From: Laura Gibbons
Sent: 01 October 2018 10:02
To: Planning.Responses
Cc: Anita Gardner
Subject: RE: Planning Consultation on: R/204/18/PL

Engineers Comments Regarding Surface Water Drainage

APPLICATION **R/204/18/PL**

Site Address: Springfield House Springfield Close Rustington BN16 2SZ

Drawing Name
Location & Block Plans

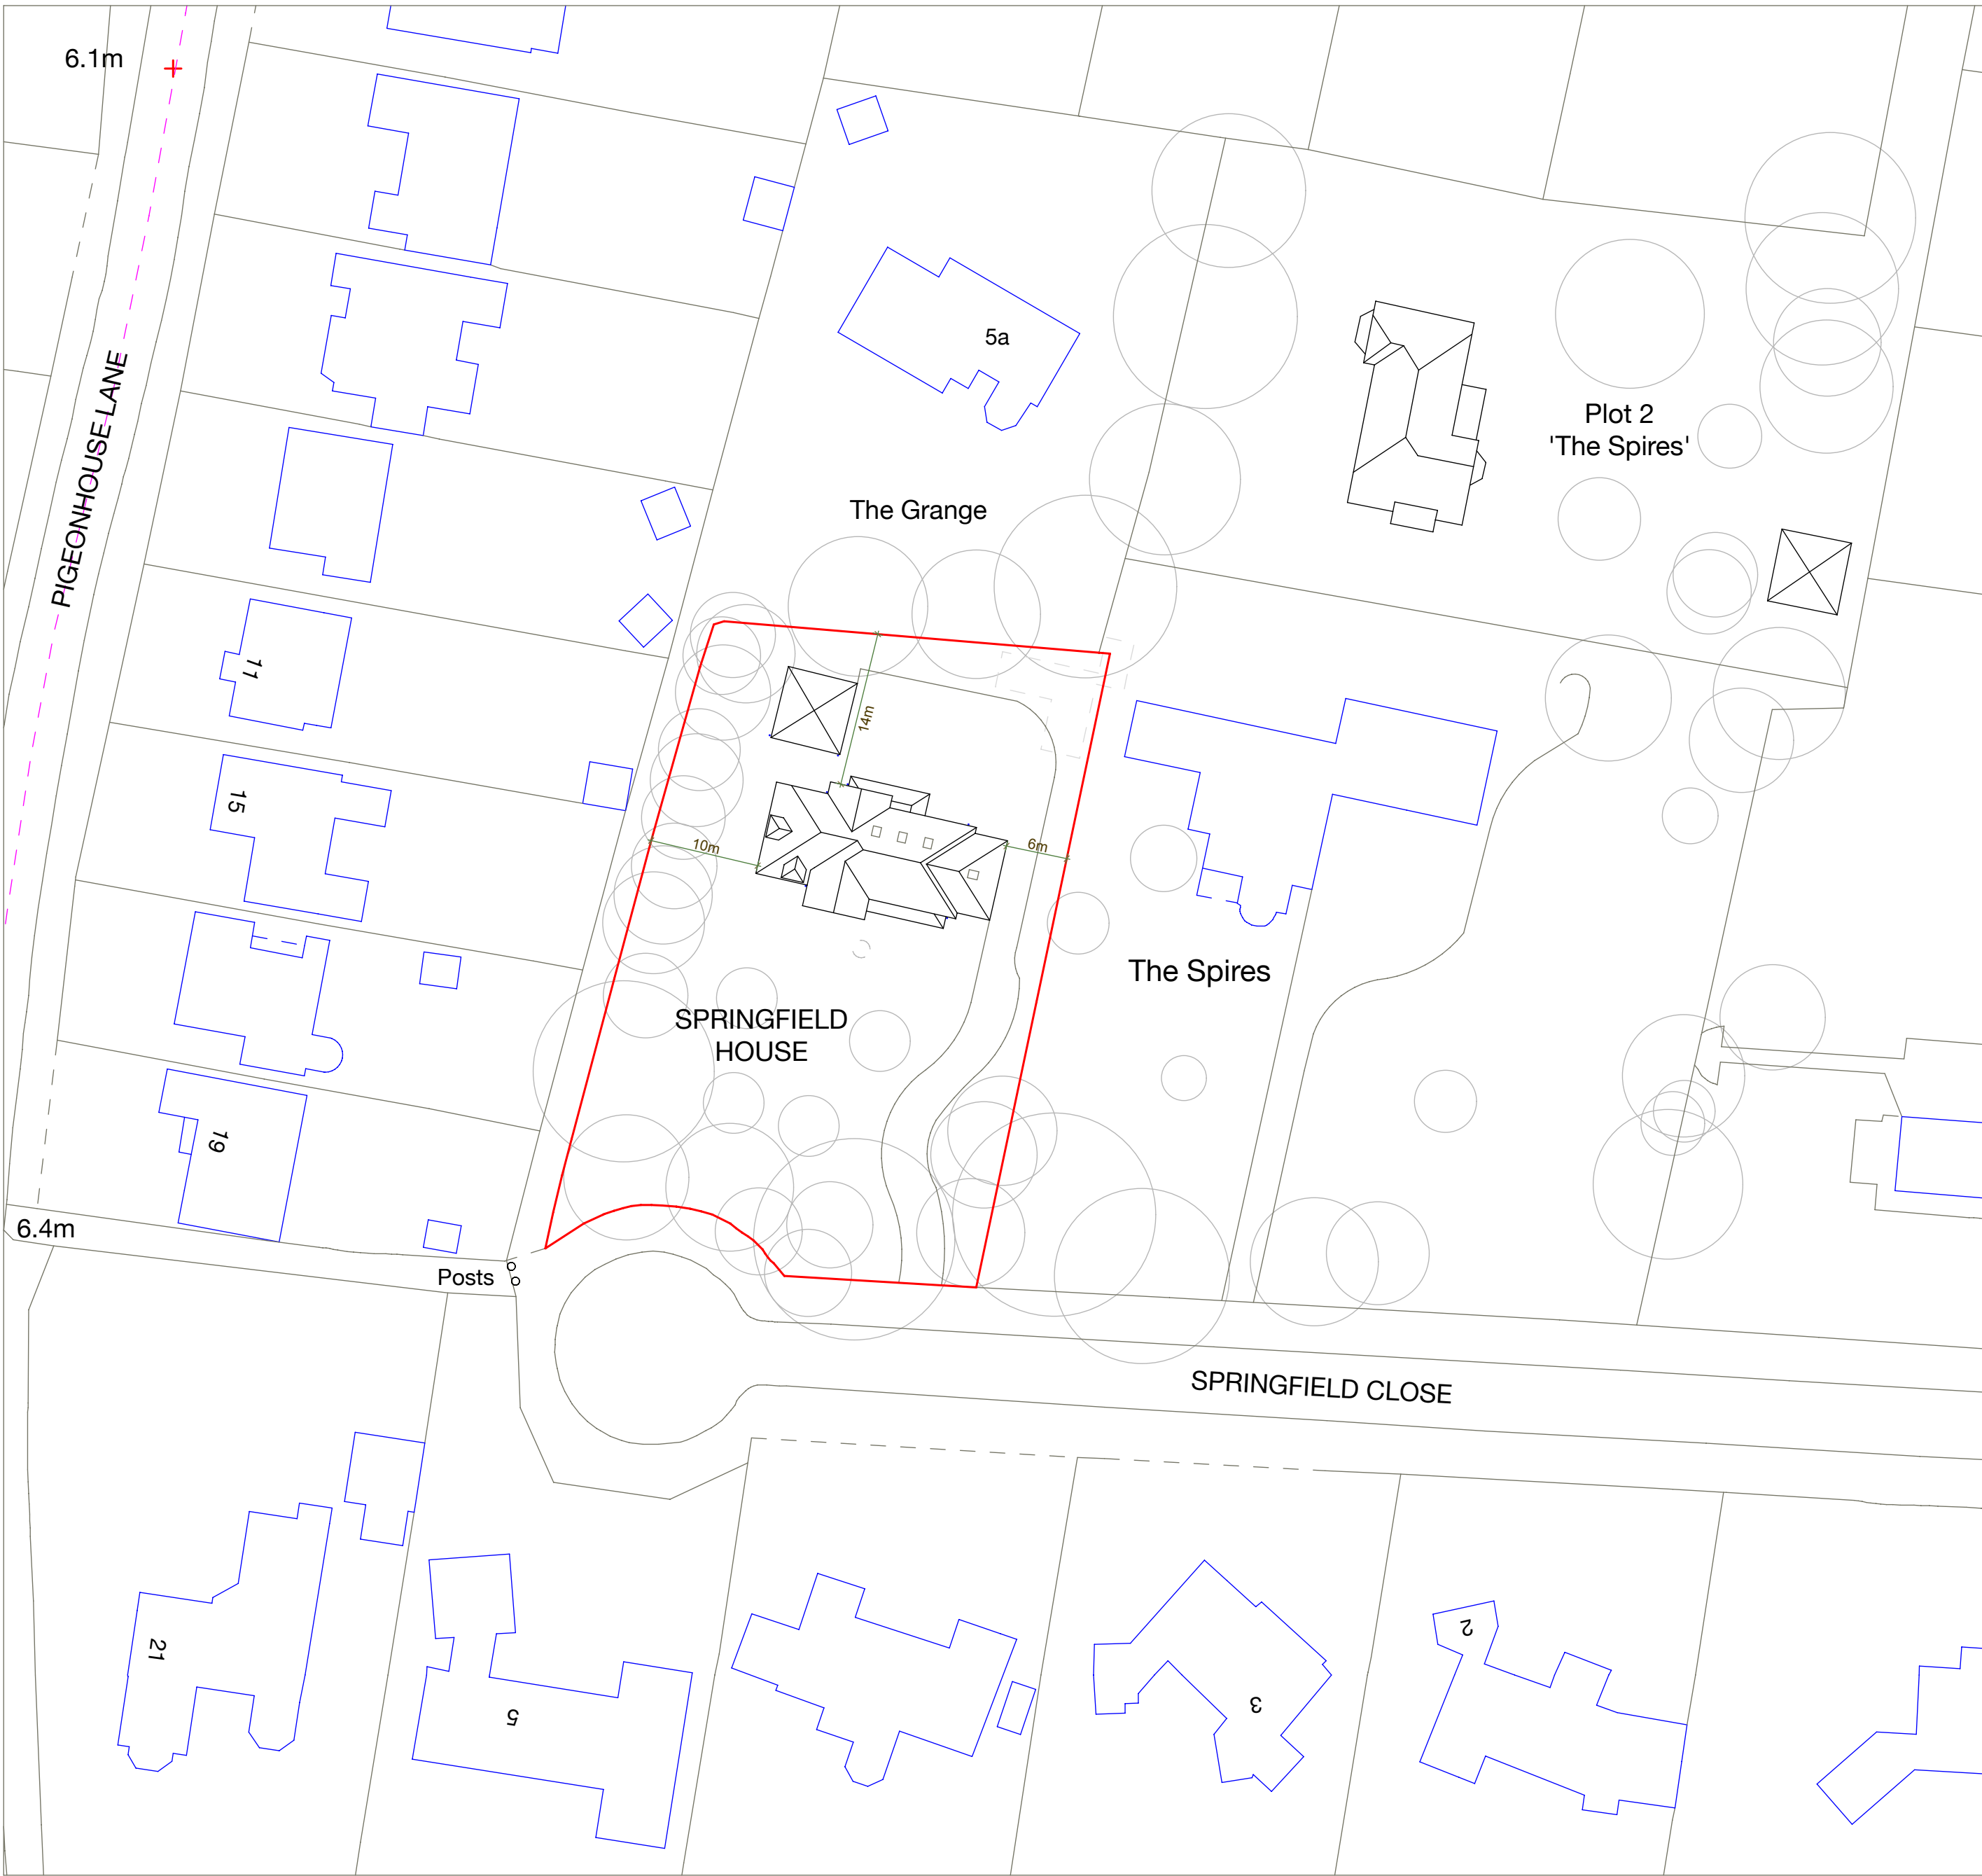
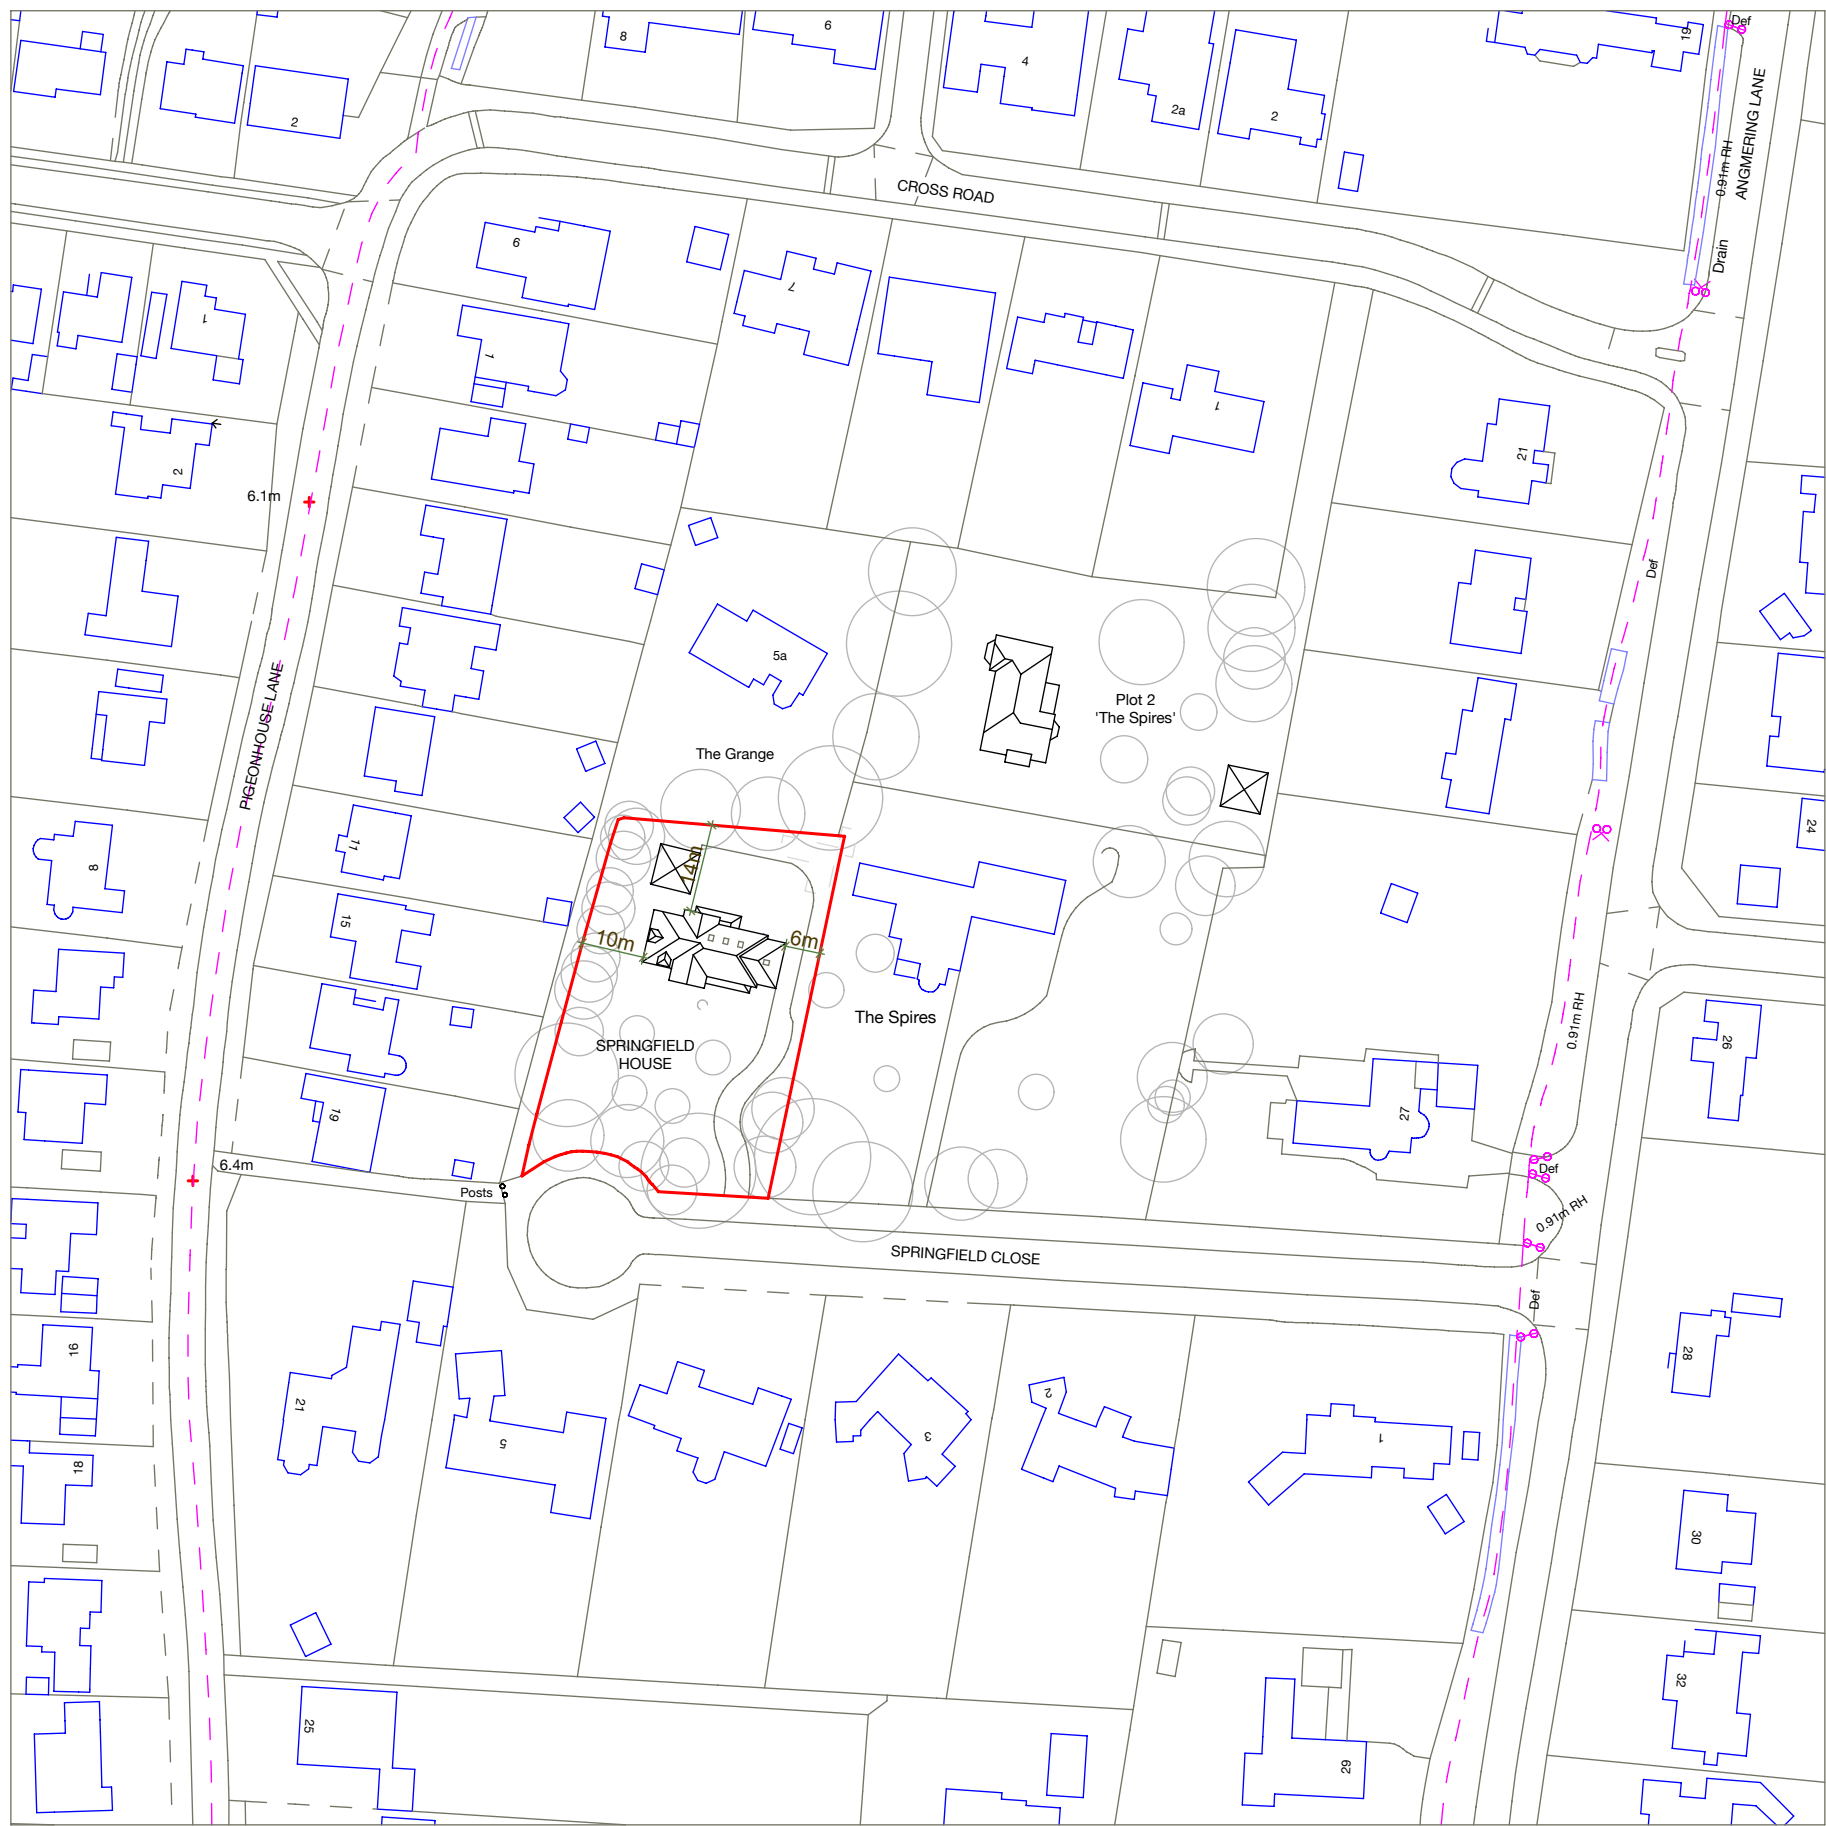
Informative: there is possibly a highways drain located within the verge on the southern boundary. This may be affected by the proposed new access road and hence may require concrete protection. It would be wise to also verify its condition.
